FW: 3/2022/0293 Ivy Cottage Parsonage Road Wilpshire invalid

Attached Drgs 3B and 4C amended as per Planning Officers email, Drg 5C also amended to show revised roof plan. I have included all the drawings for ease.

DRG NO 4/A/B/
C/A/B/

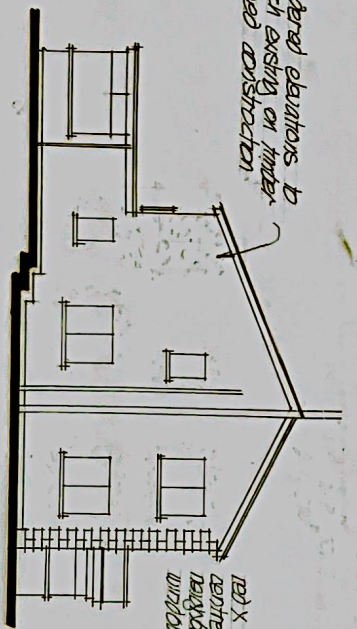
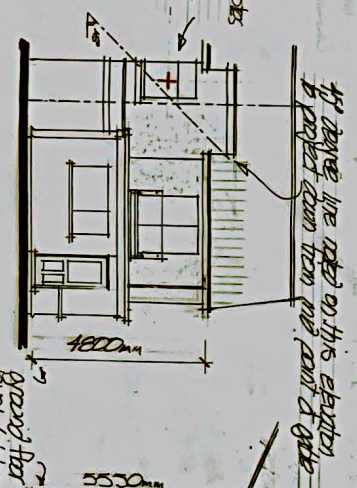
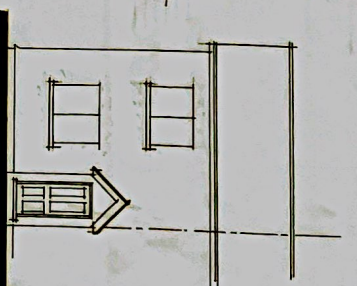
- The hipped roof design on the extension would be visually jarring with the existing roof profile I would switch the hipped roof back to a gabled roof as was originally proposed

- Proposed elevation drawing (for the purposes of clarity):
 - o Amend extension drawing to show a gabled roof (denoted in black in above attachment)
 - o Draw a 45 degree line down from mid-point of gable roof (denoted in black in above attachment)

- Draw a red cross on neighbouring window to denote centre point of window (denoted by red cross in above attachment)
 - o Remove hatched area from drawing (denoted by green arrow in above attachment)

DRG NO 3/AB

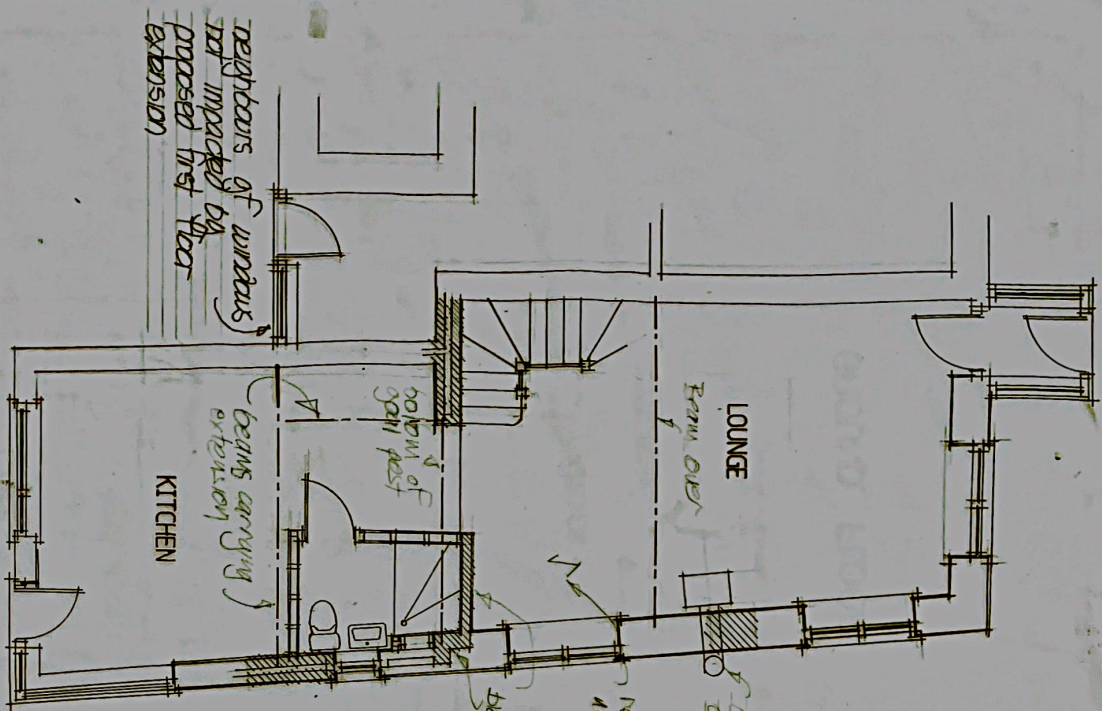
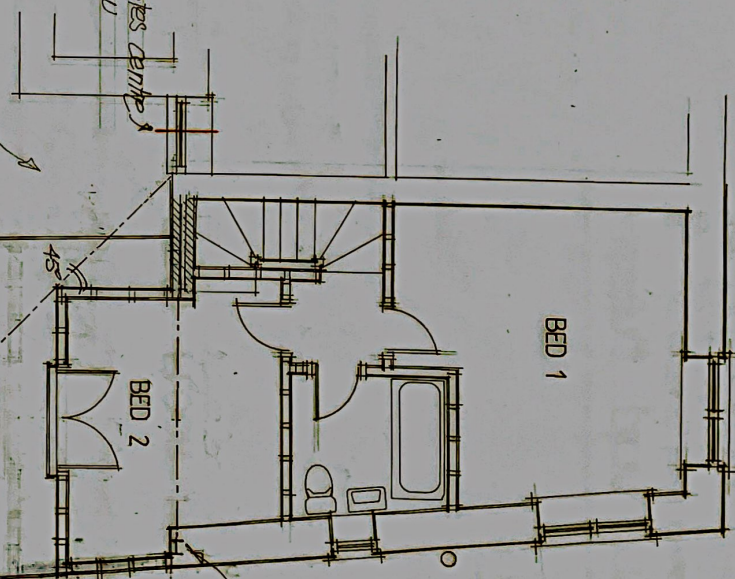
- Proposed floor plan drawing (for the purposes of clarity):
 - o Remove hatched area from drawing (denoted by green arrow in above attachment)
 - Draw a vertical line on neighbouring window to denote centre point of window (denoted by red vertical line in above attachment)

- o Remove 45 degree mark / re-draw the 45 degree mark on the corner of the extension (denoted in black in above attachment)
